# Rezoning Transportation Analysis

Petition Number: #2022-123

## Revision Log:

Date	Description
12-28-22	First Review (TM)
01-24-23	Second Review (DR)
02-23-23	Third Review (DR)

REZONING PLAN
RZ.01

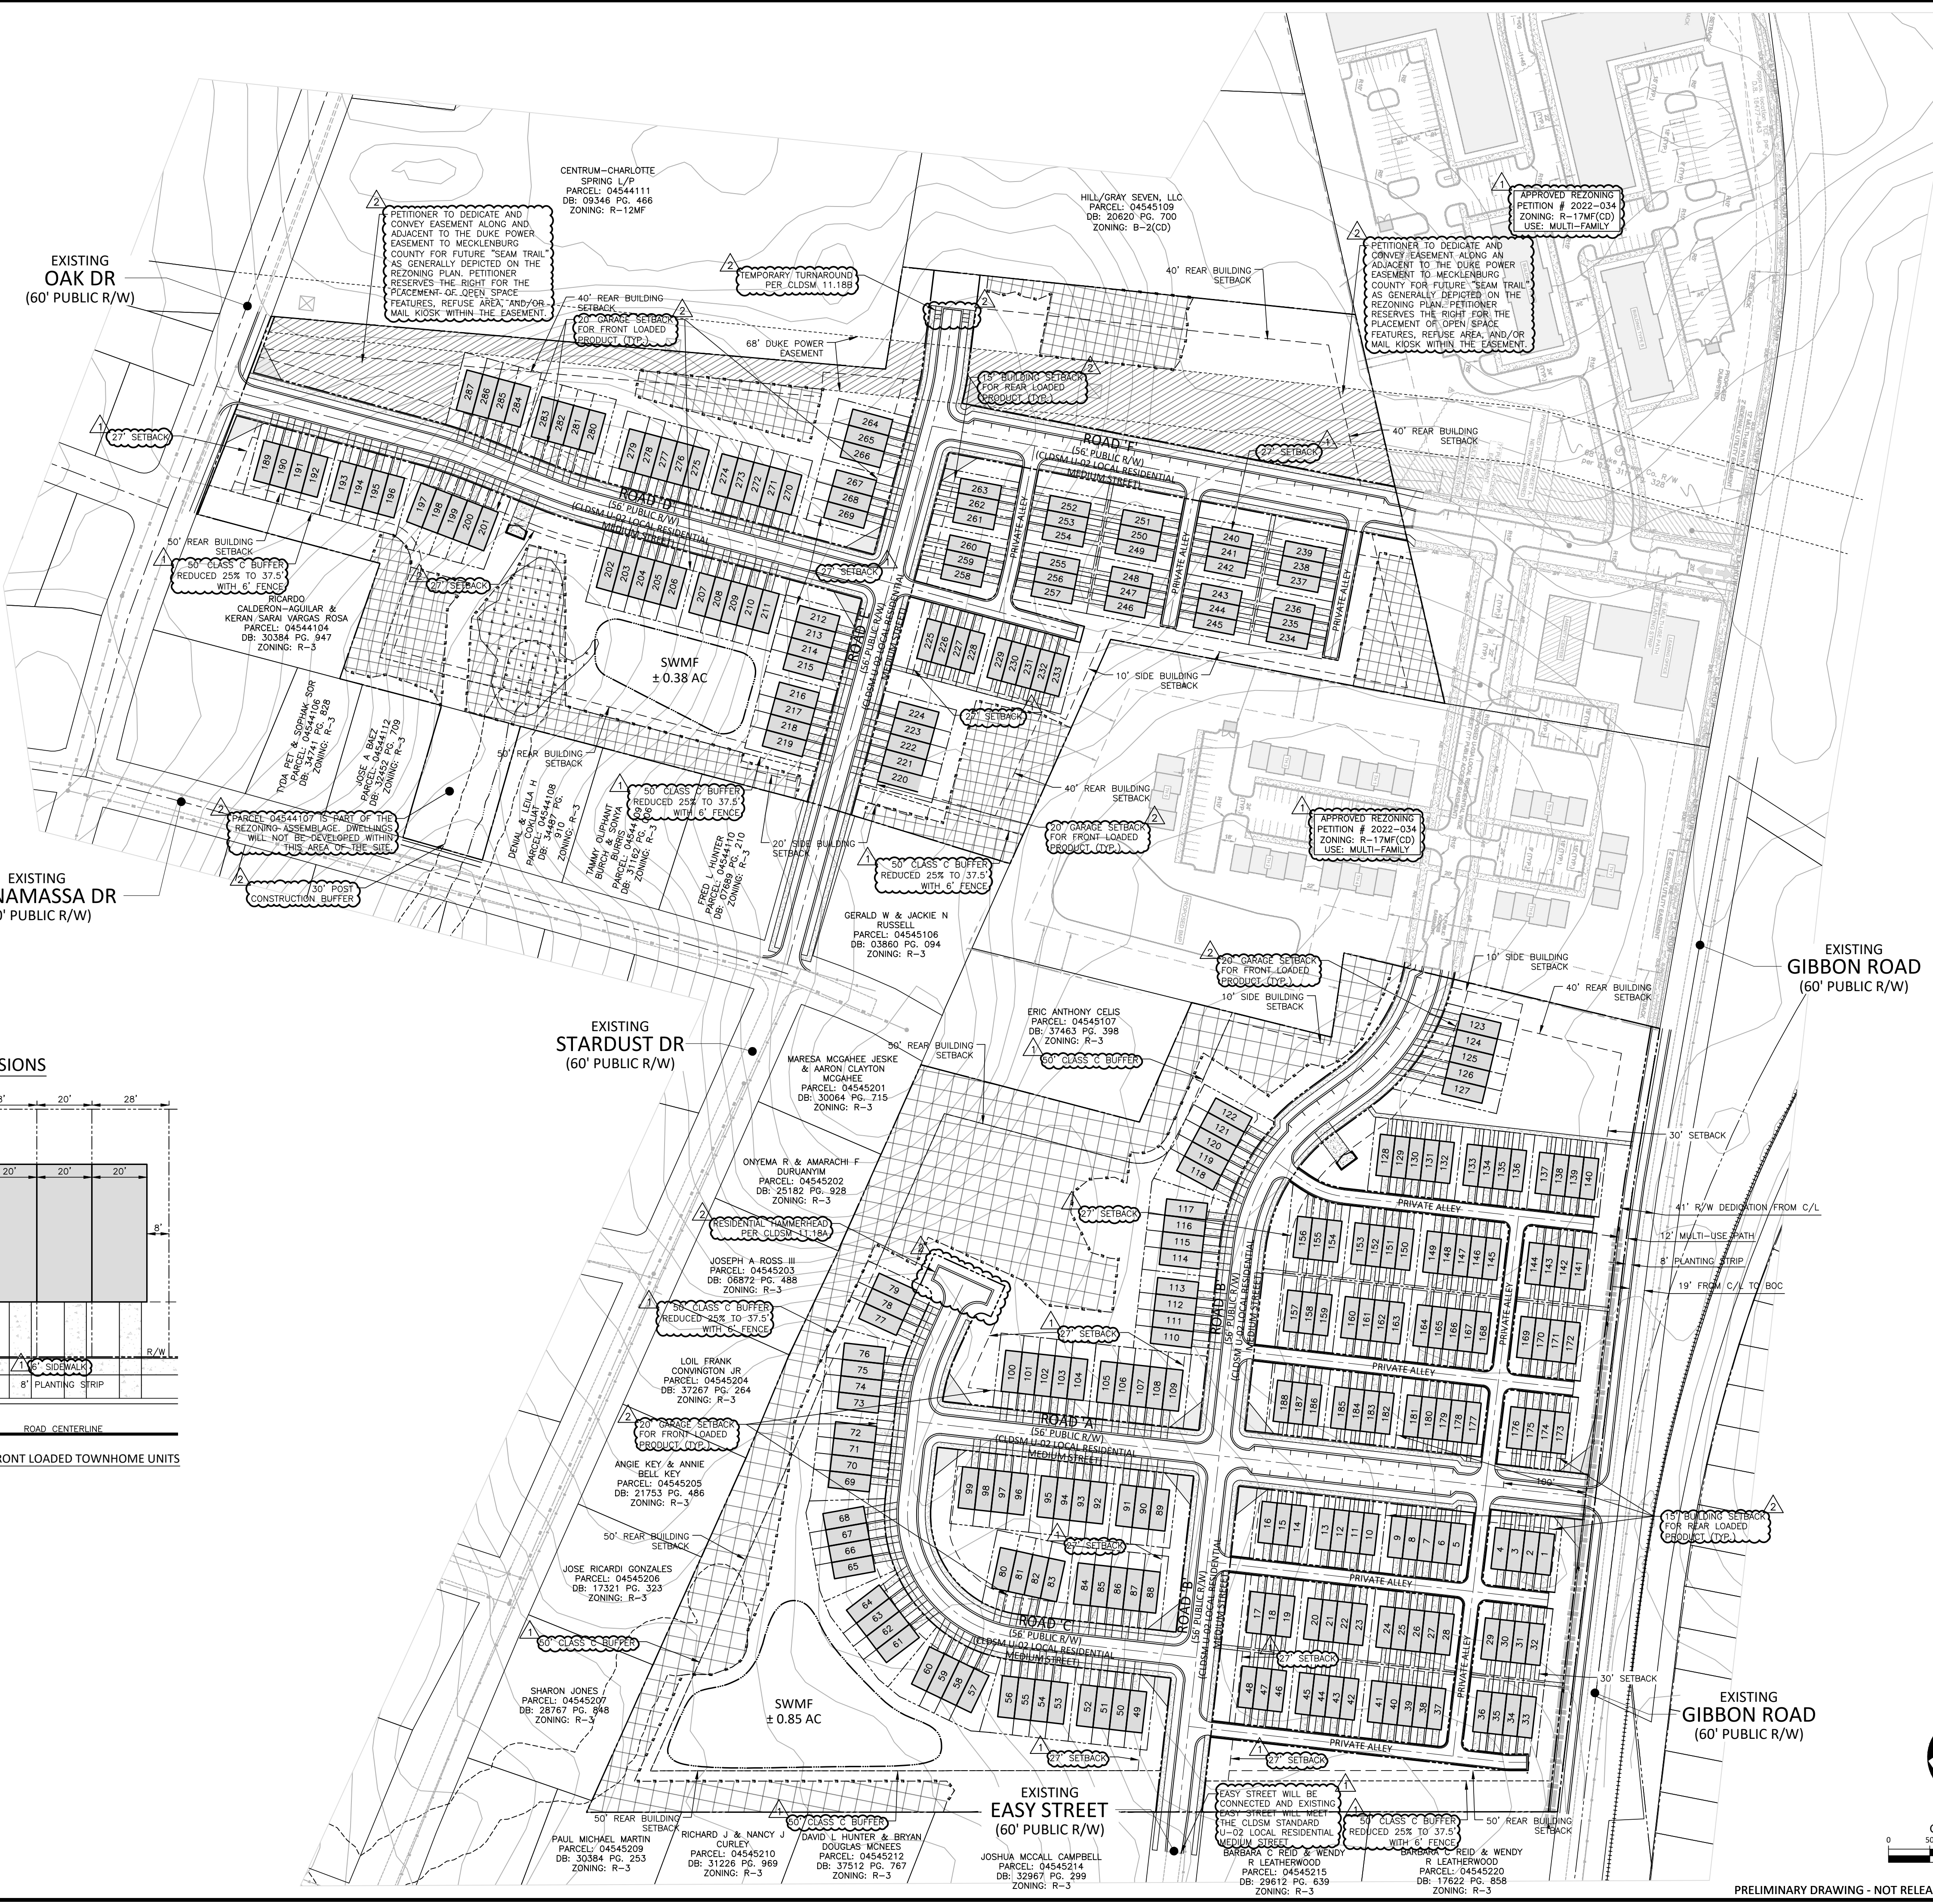
- a. ~~Gibbon Road:~~ Location of curb and gutter to be moved to 19 feet from roadway centerline to accommodate the Charlotte Streets Map with a roadway typical section of CLDSM 11.09 Minor Thoroughfare.
- b. **New Comment from 2-23-23: Oak Drive:** Curb and gutter shall be placed along the entire site's frontage. Label and dimension the proposed curb line from the exiting centerline of the road.
- c. **New Comment from 2-23-23: Wanamassa Drive:** Curb and gutter shall be placed along the entire site's frontage. Label and dimension the proposed curb line from the exiting centerline of the road.

- 4. **New comment from 02-23-2023:** Revise conditional note(s) to commit to dedicate 28-feet of right-of-way from the road centerline along Wanamassa Drive in coordination per CLDSM Local Residential Medium Street and 30-feet of right-of-way from the road centerline along Oak Drive in coordination per CLDSM Residential Collector. The site plan shall label and dimension the right-of-way from the road centerline.

- New comment from 02-23-2023:** Revise site plan and conditional note(s) to commit to construct an 8-foot planting strip and 6-foot sidewalk along the site frontages on Oak Drive and Wanamassa Drive. The site plan shall label and dimension both items from the back of curb and gutter and road centerline.
- New Comment from 1-24-23:** Ensure that public road F connects to the public road A from rezoning petition 2022-034. Clearly show the connection. It is unclear from the site plan if the connection is being made.
